**\*PRE-HEARING STAFF ANALYSIS\***

**Rezoning Petition No. 2008-35**

**Petitioner:** Charlotte Mecklenburg Housing Partnership

**Location:** Approximately 10.4 acres on both sides of Statesville Avenue between Woodward Avenue and Dearborn Avenue

SP101

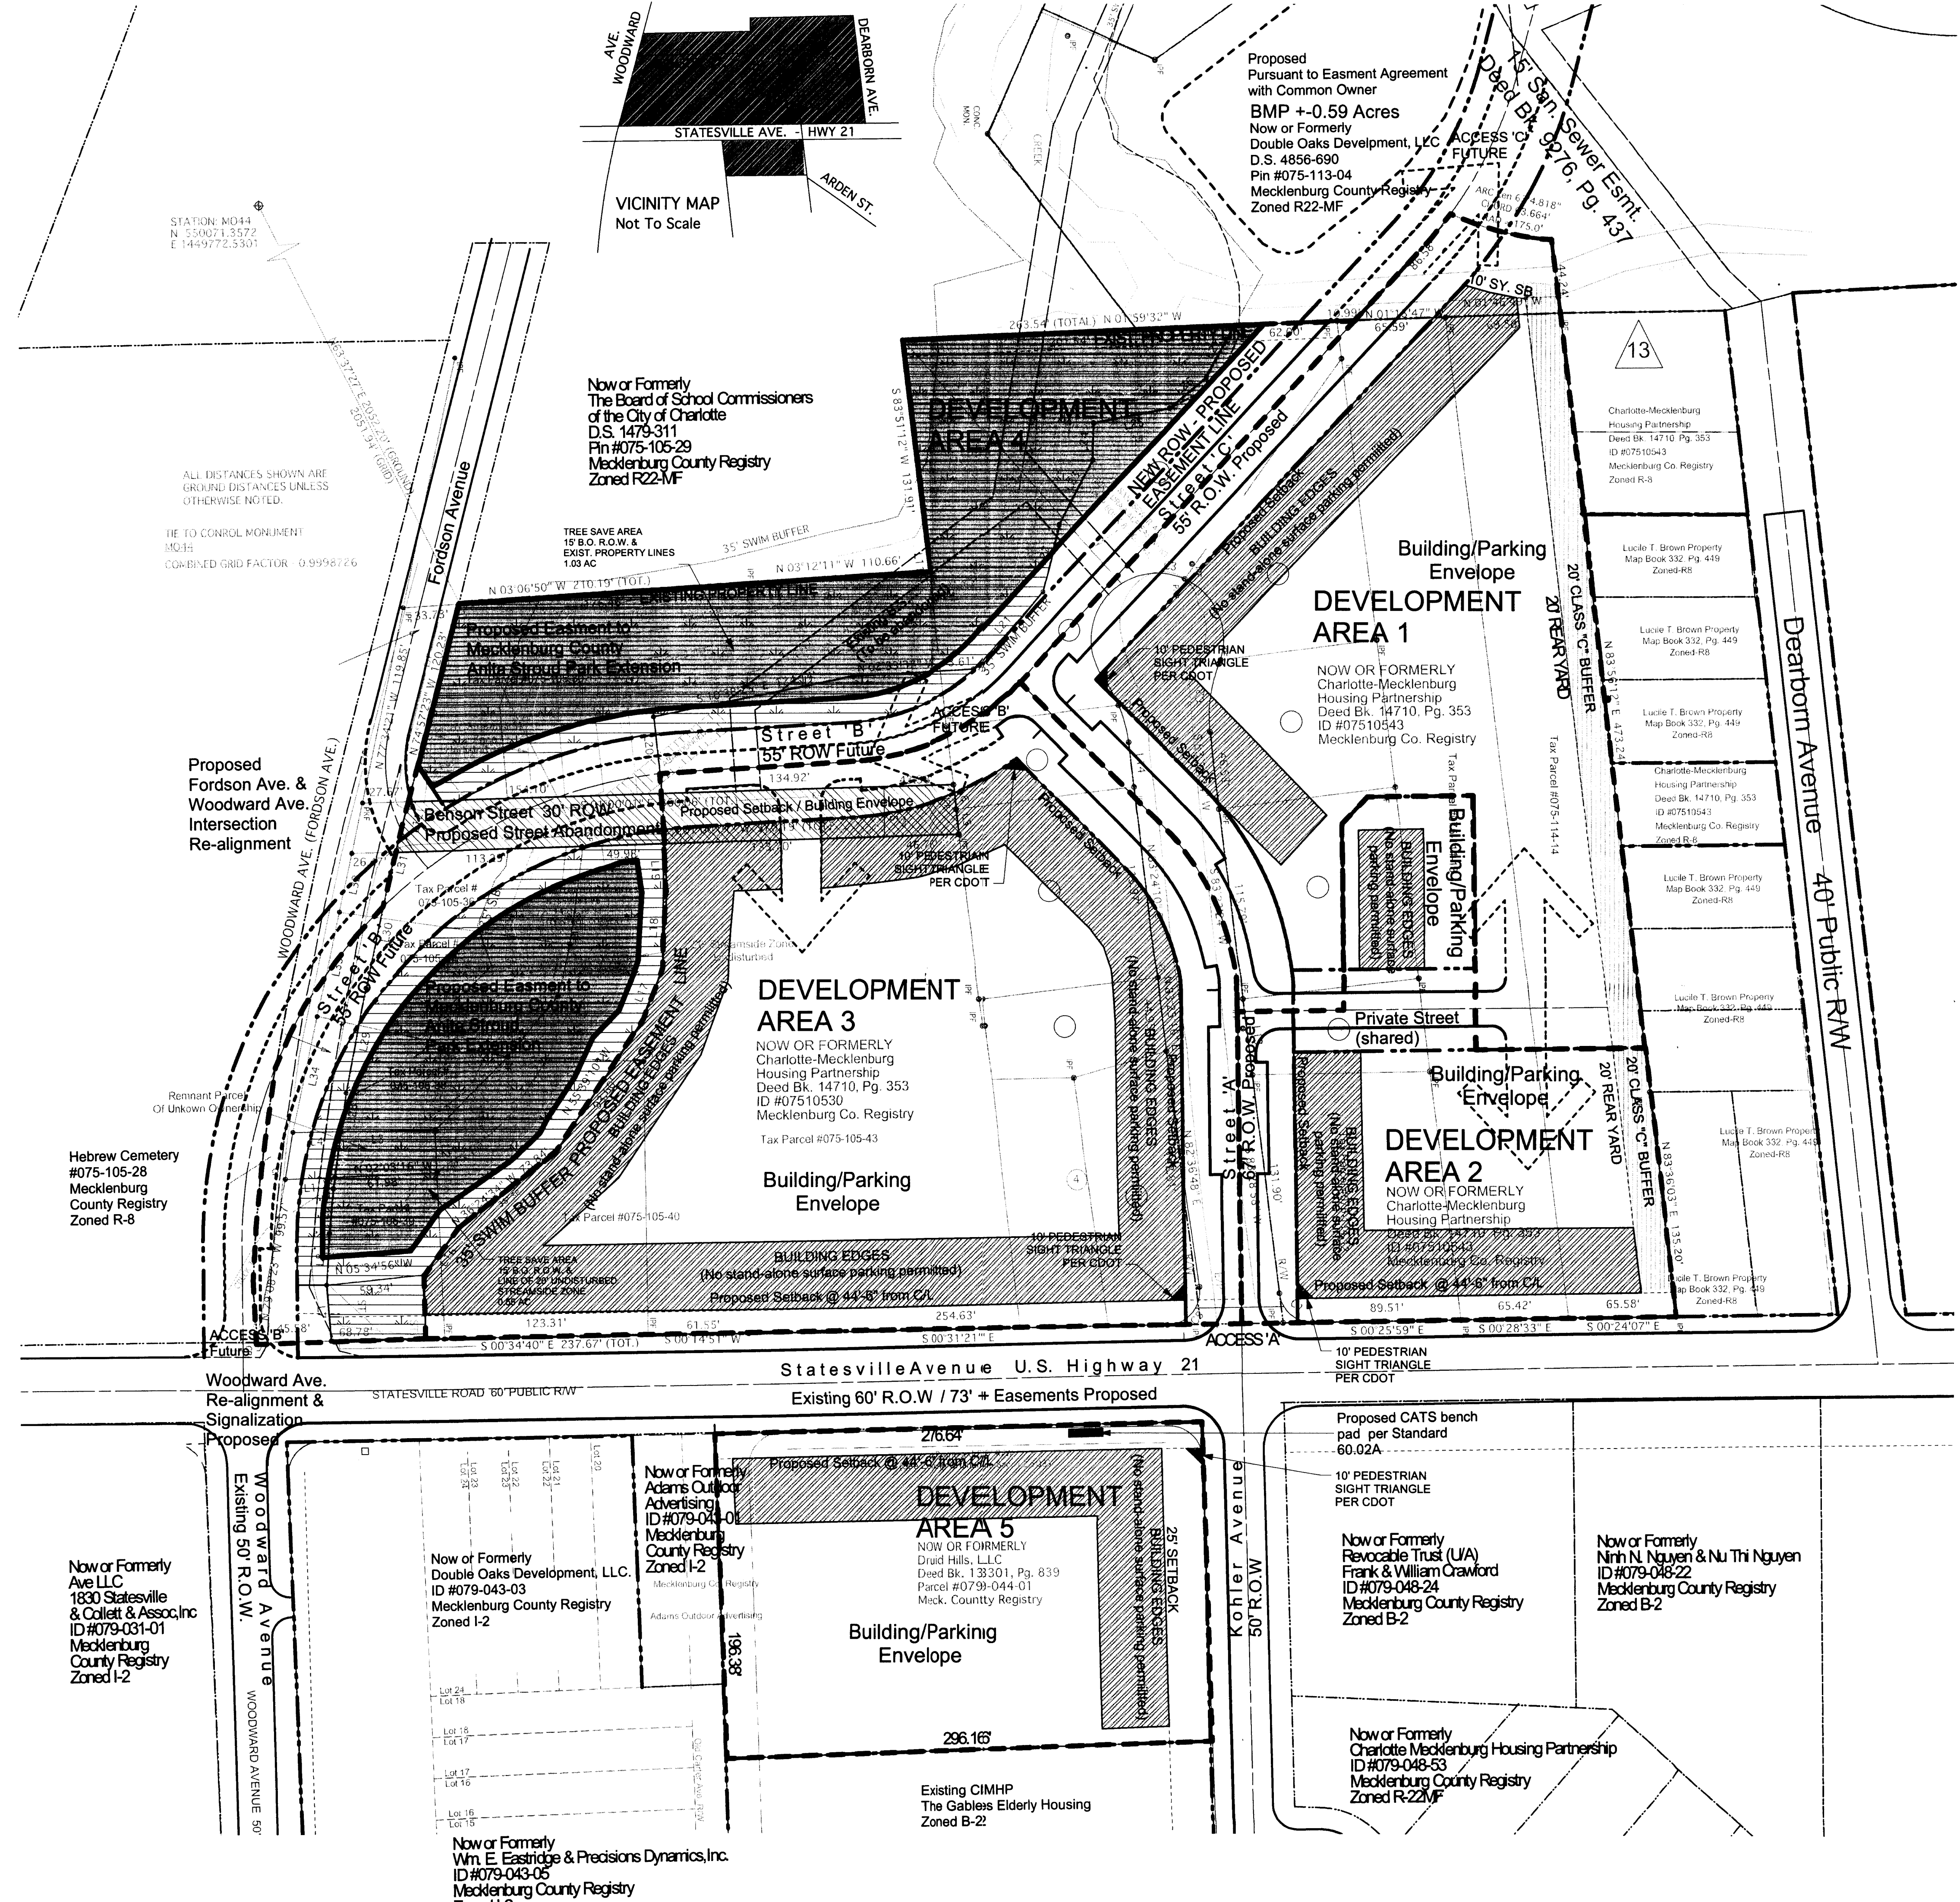
- The proposal to limit building height to 50 feet within 25 feet of the northern boundary is inadequate. The building height needs to be lower or the separation wider.
- The building envelopes and parking fields for several of the development areas are not realistic and need to be reconfigured.
- The greenway note needs to be modified to preclude placement of water quality BMPs within the greenway.
- The concerns raised by CDOT need to be satisfactorily resolved.
- Note 2.1. needs to be modified to state that outdoor dining areas will be counted for parking requirements.
- Parking requirements need to be stated as one space per 125 square feet of restaurant floor area, one space per 300 square feet of retail space, and one space per 400 square feet of office floor area.
- The "gap" identified by MCPR needs to be closed as part of the site plan.

Schematic Plan Petition #2008-35

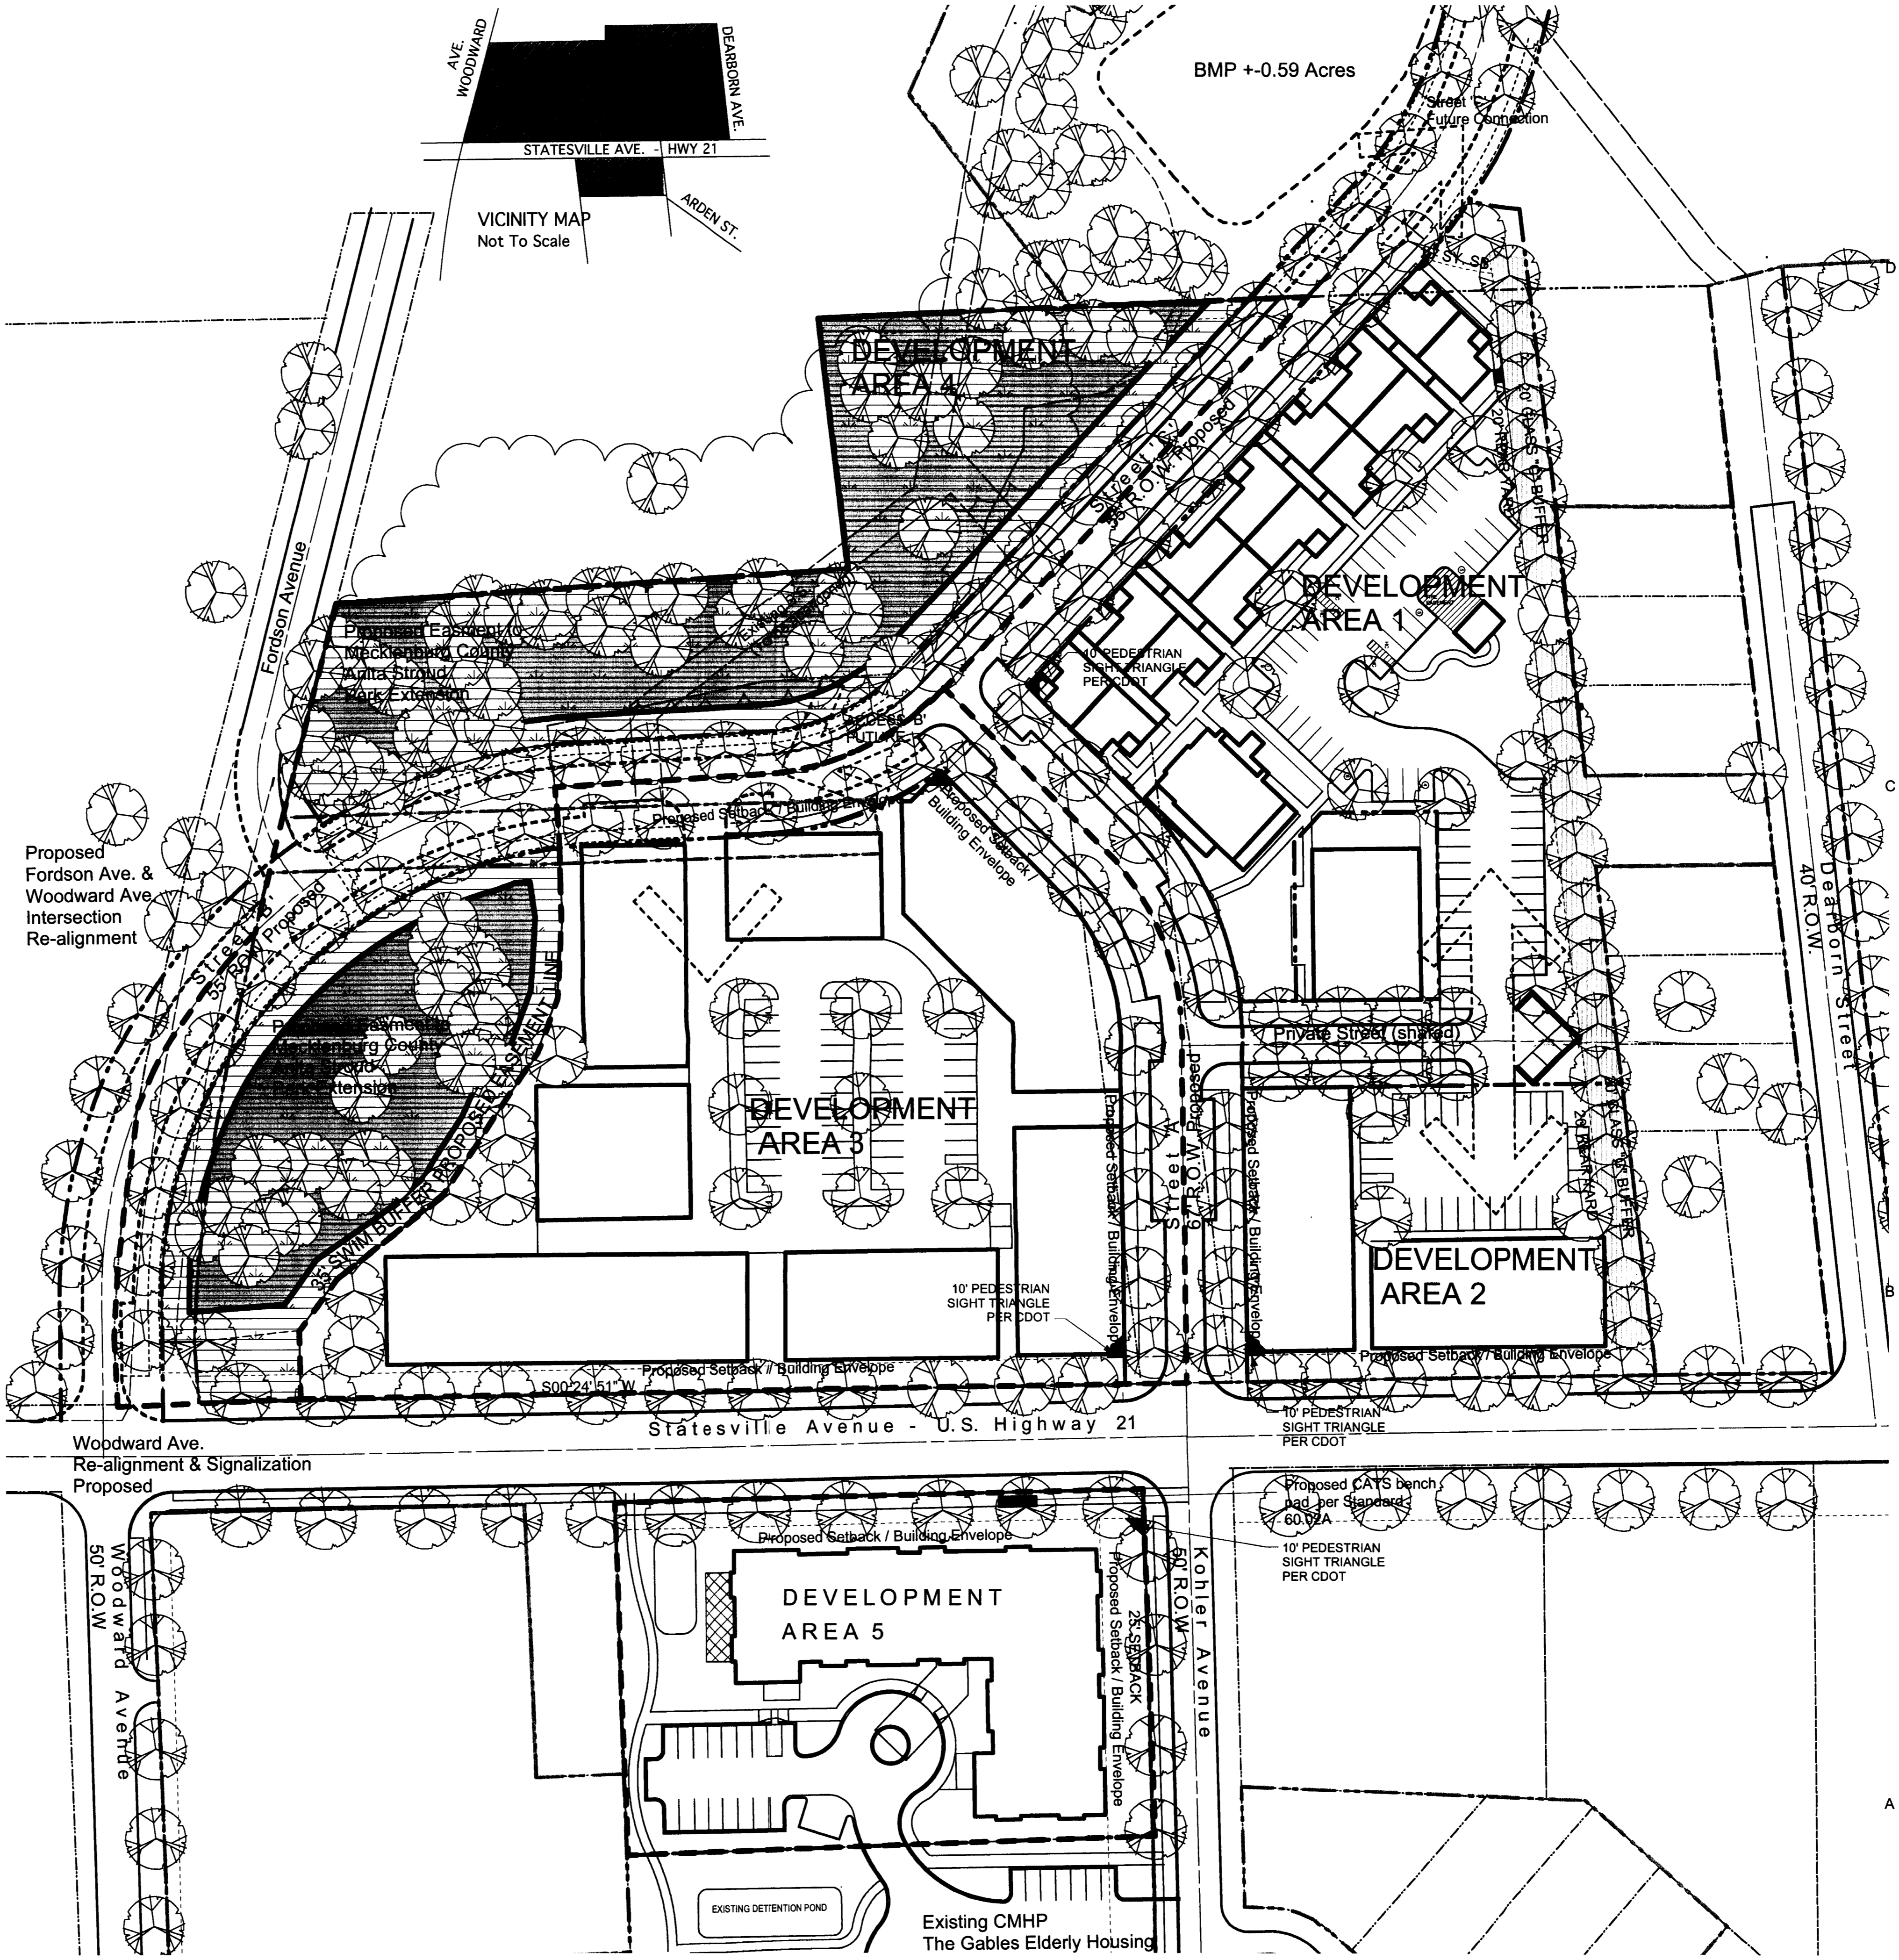
**Mecklenburg County Parks and Recreation.** MCPR wishes to note that additional land outside of the area encompassed in this rezoning will be required to connect the proposed easements to Anita Stroud Park. This approximately 200' gap exists north of the area entitled "Development Area 4" and adjacent to the proposed BMP as shown on the Schematic Plan dated 1/18/08.
